## Response to Planning application from Hertfordshire County Council (T and CP GDP Order 2015)

District ref: 6/2022/2146/ADV  
HCC ref: WH/13866/2022  
HCC received: 20 September 2022  
Area manager: Matthew Armstrong  
Case officer: Steven Knight

H R OWEN MOSQUITO WAY HATFIELD AL10 9WN

Installation of signage to facade of east and west buildings together with site wide totem wayfinding signage

Drawn	Date	Checked	Scale @ A1
FS	APR 2022	MRW	1:100
Job No	Drawing No	Revision	Note
2019-48	E-301

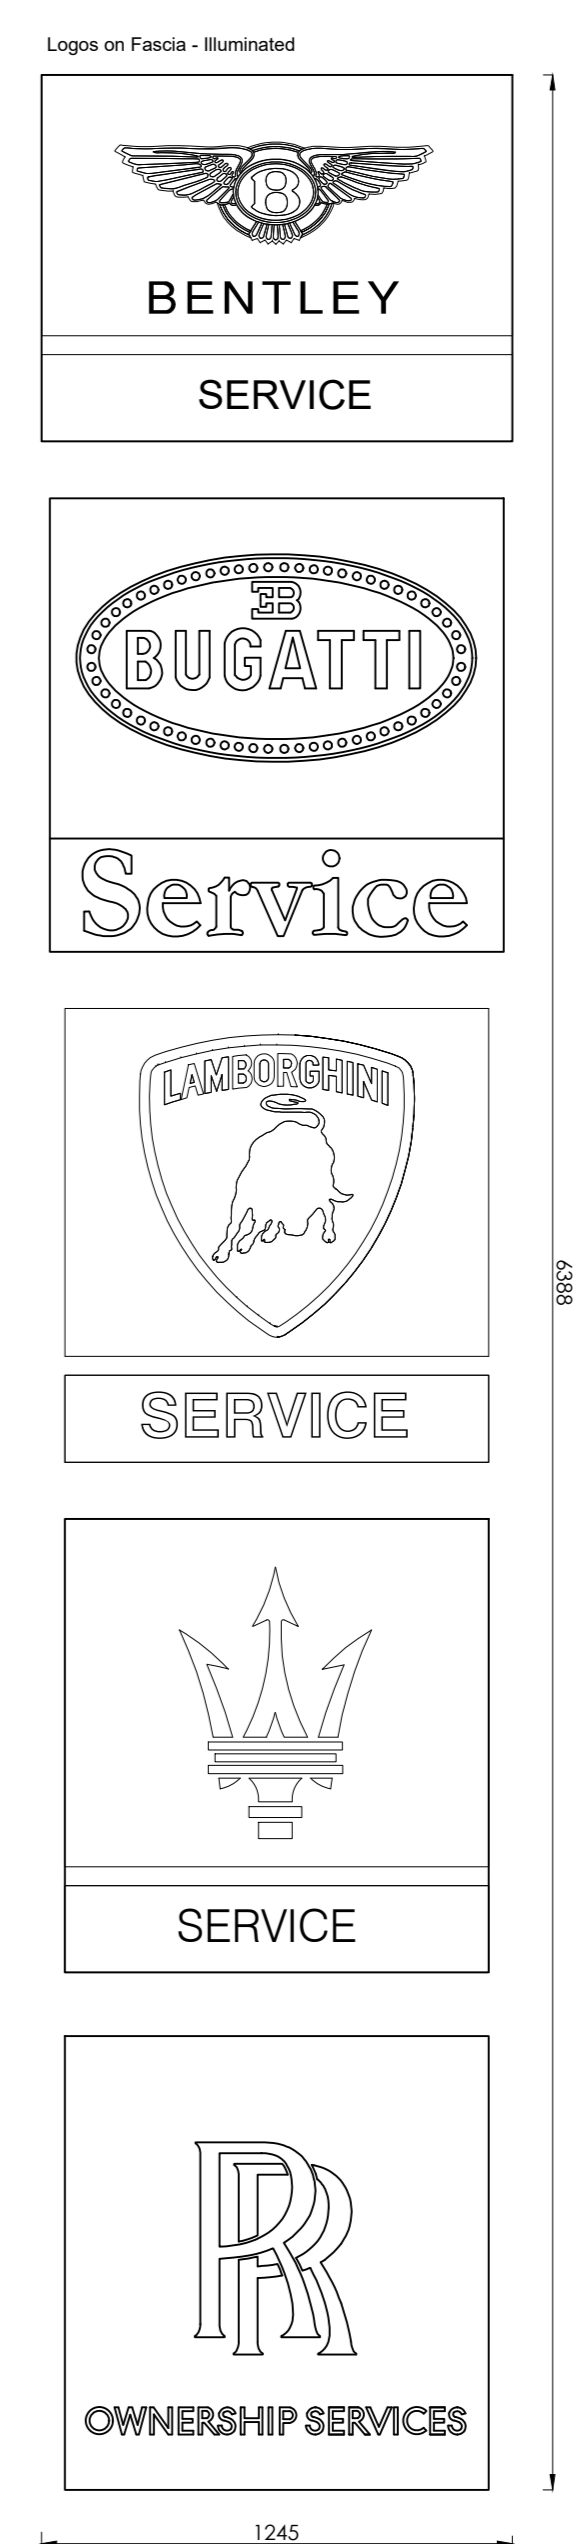
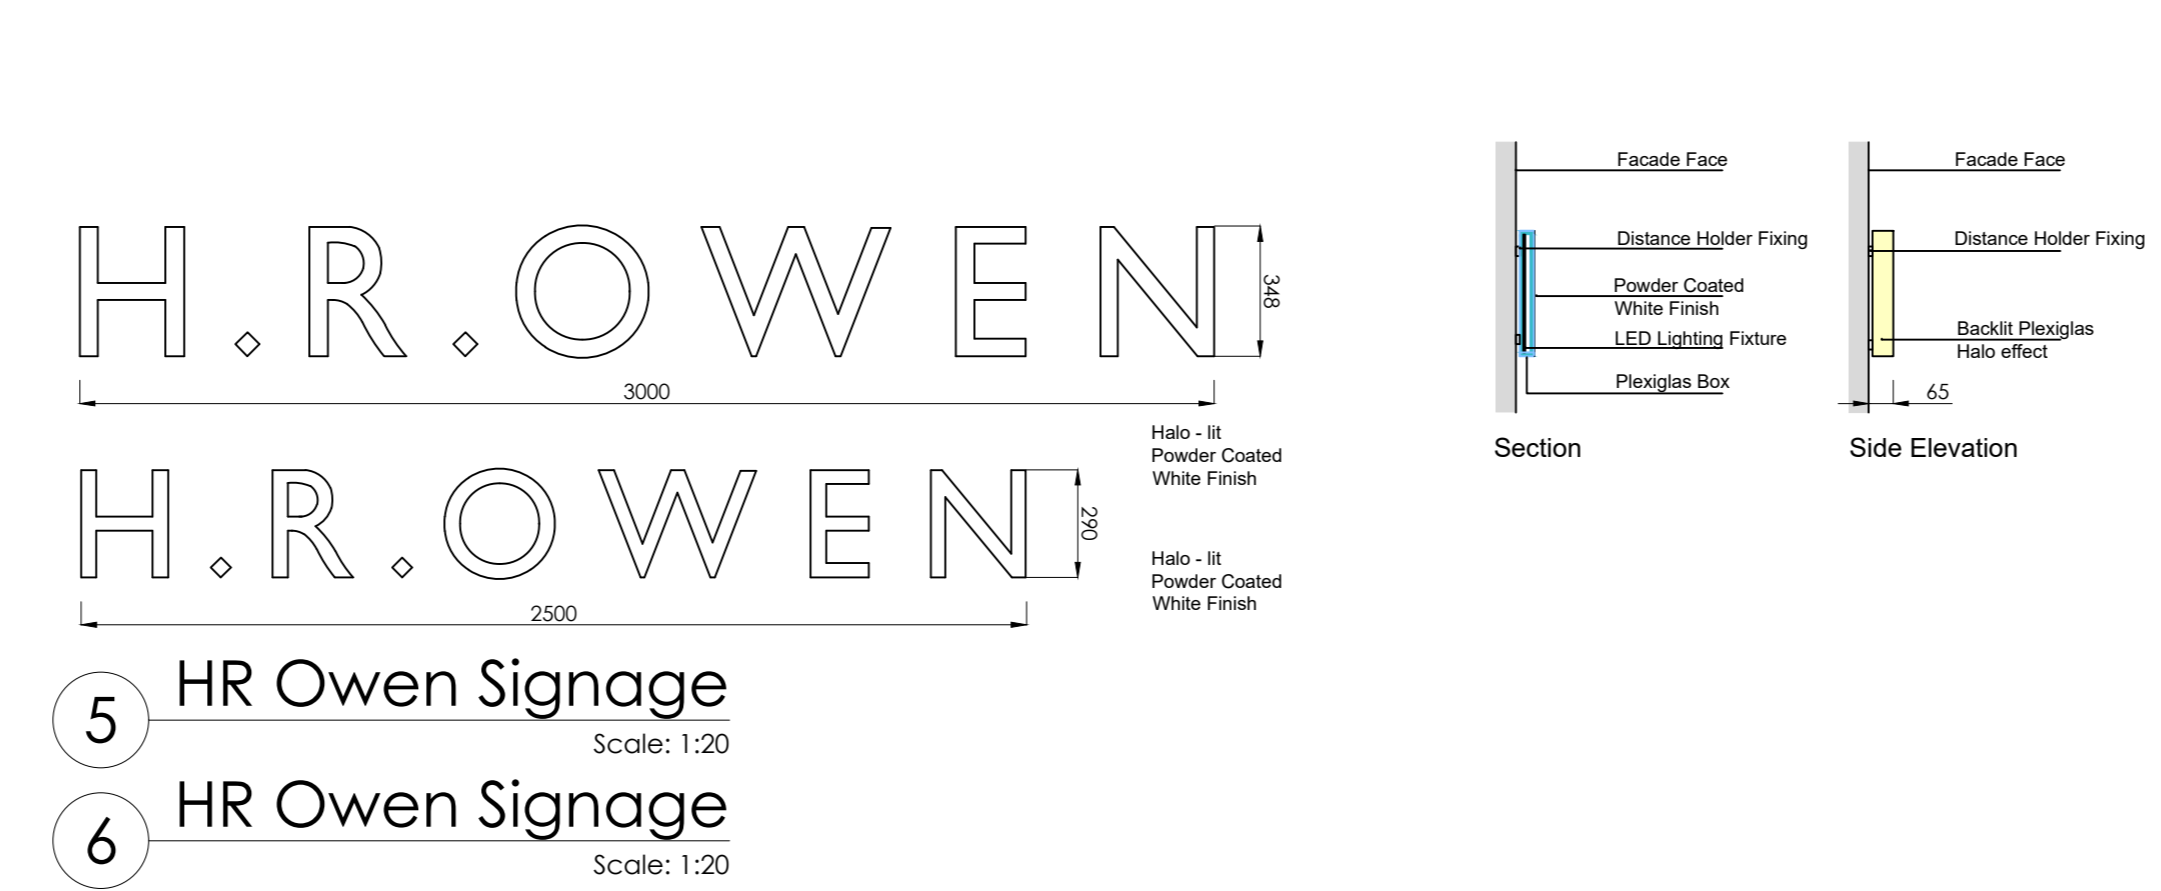
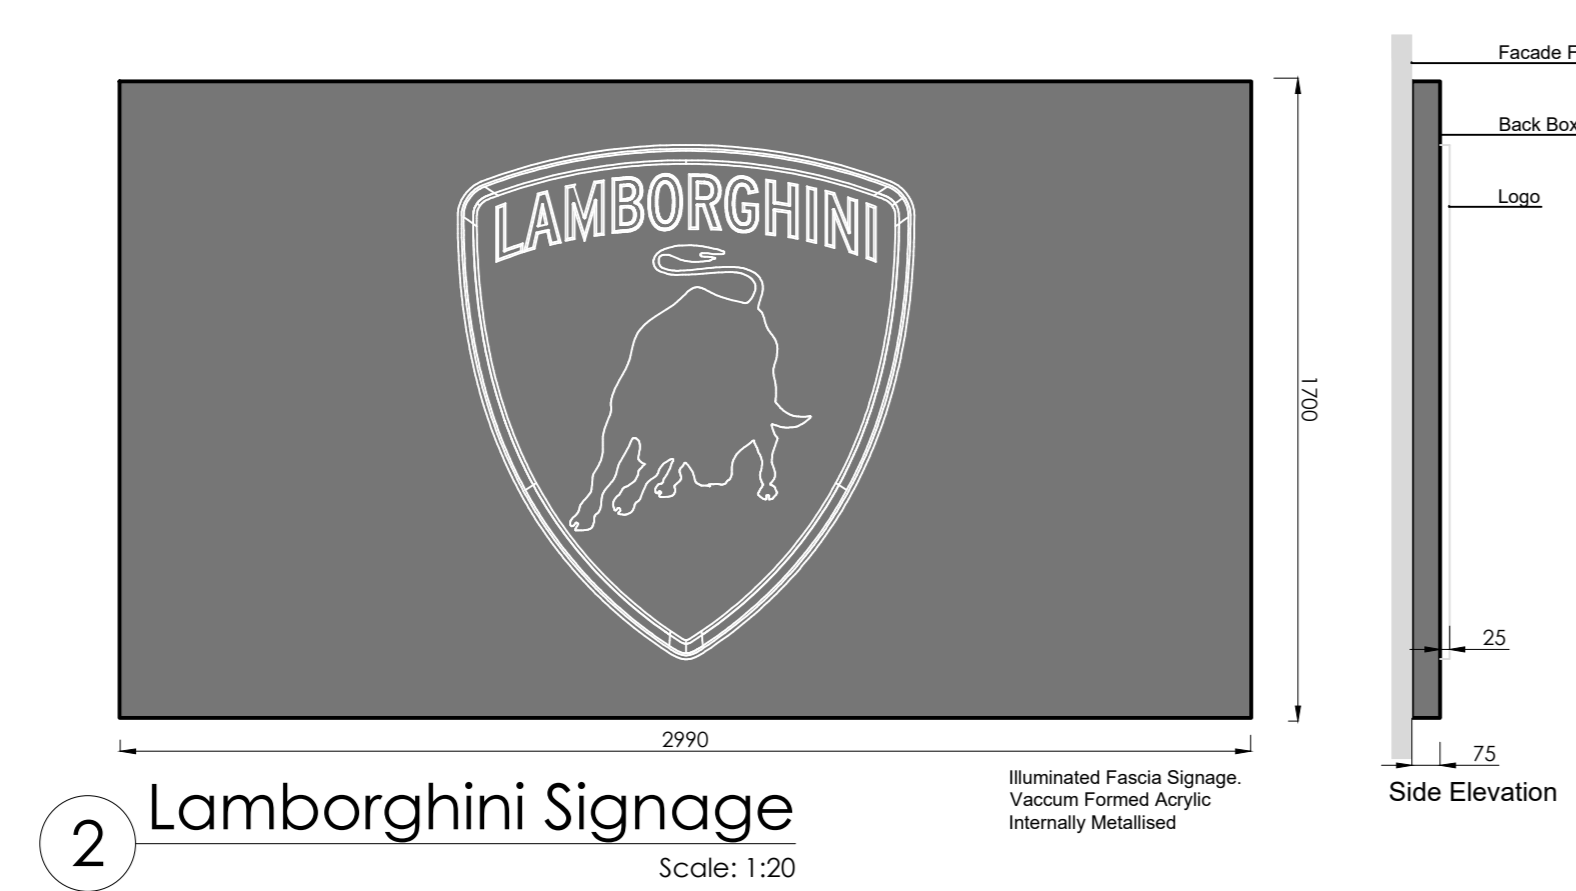
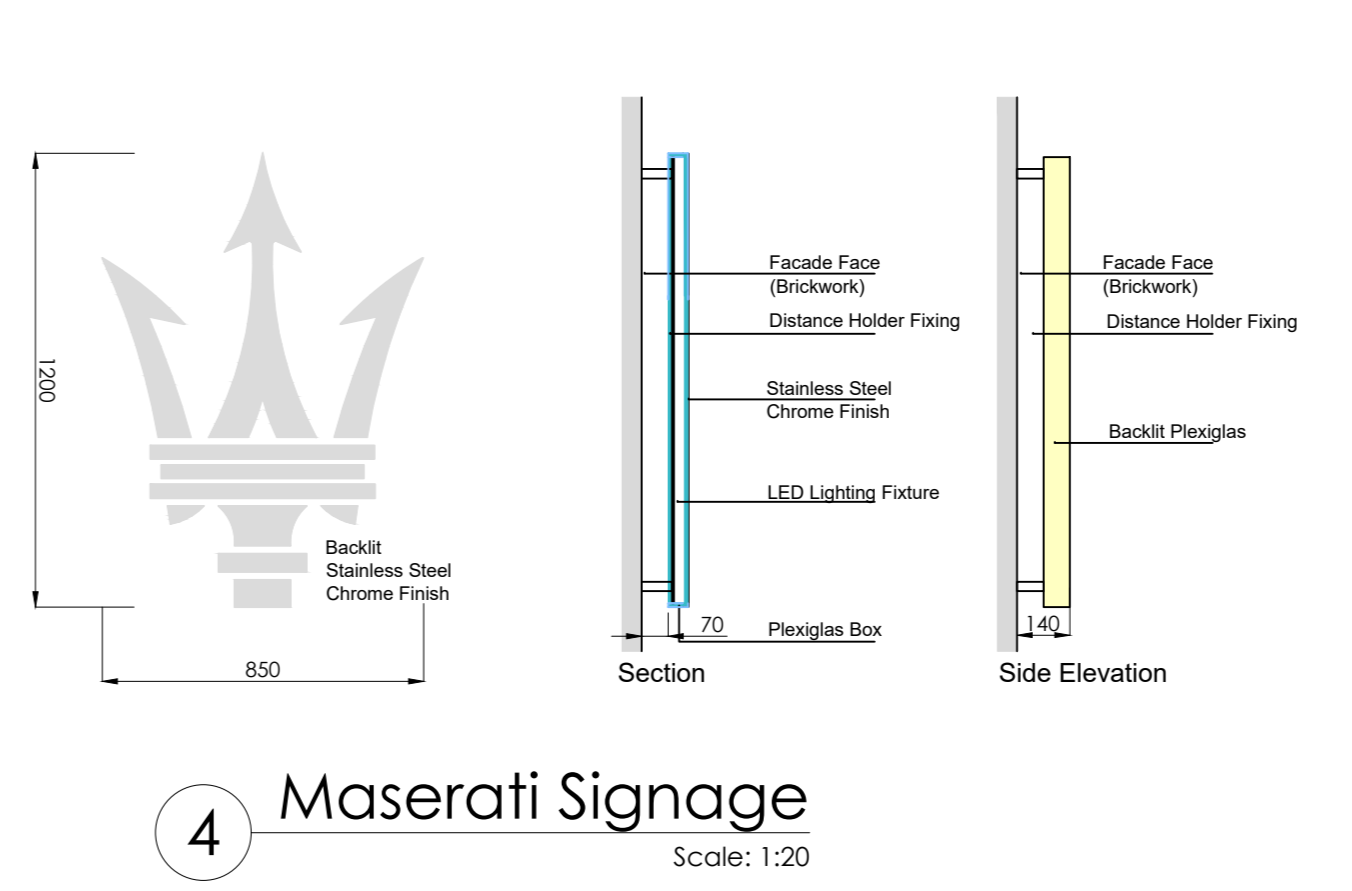
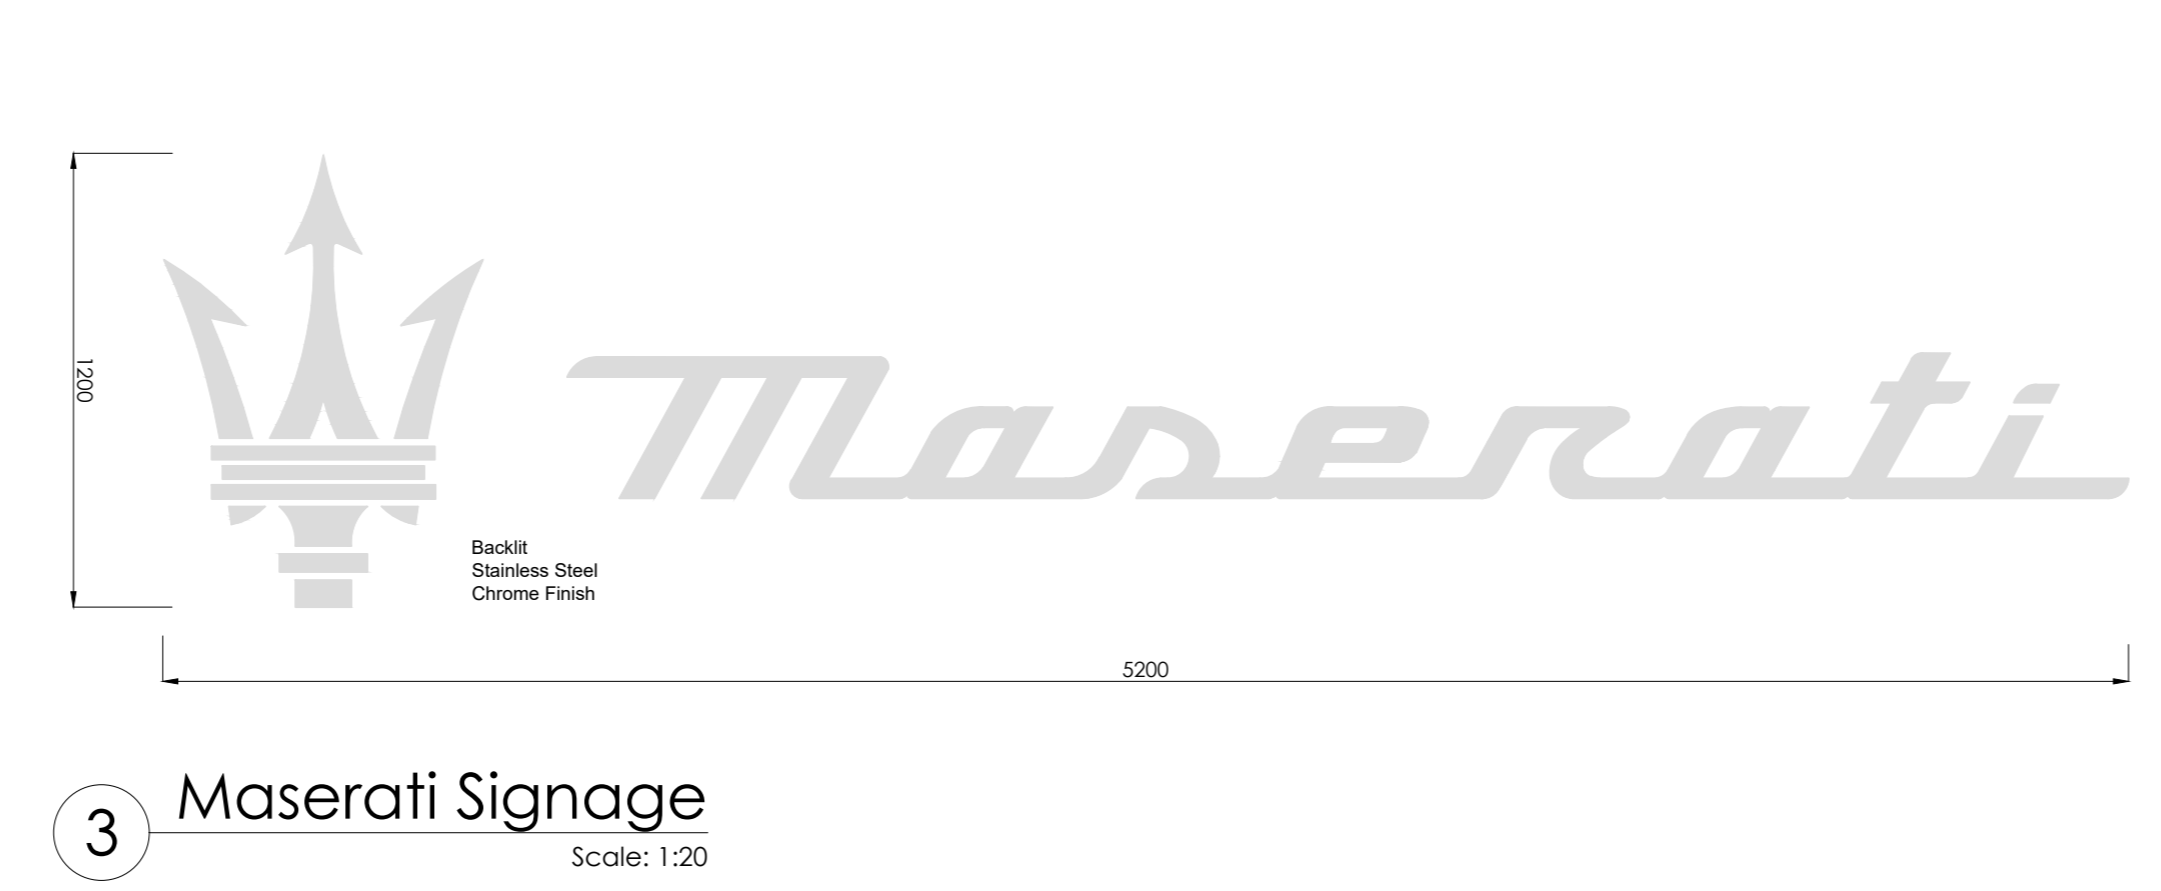
It is assumed that the LED screens will be used in relation to the garages below them rather than to advertise as they are not aimed directly at the highway. They will, however, be visible to drivers heading north-east on Mosquito Way and the style and speed of the intermittent images should be considered to ensure they are not distracting the drivers. The highway authority therefore recommends the inclusion of the condition listed above.
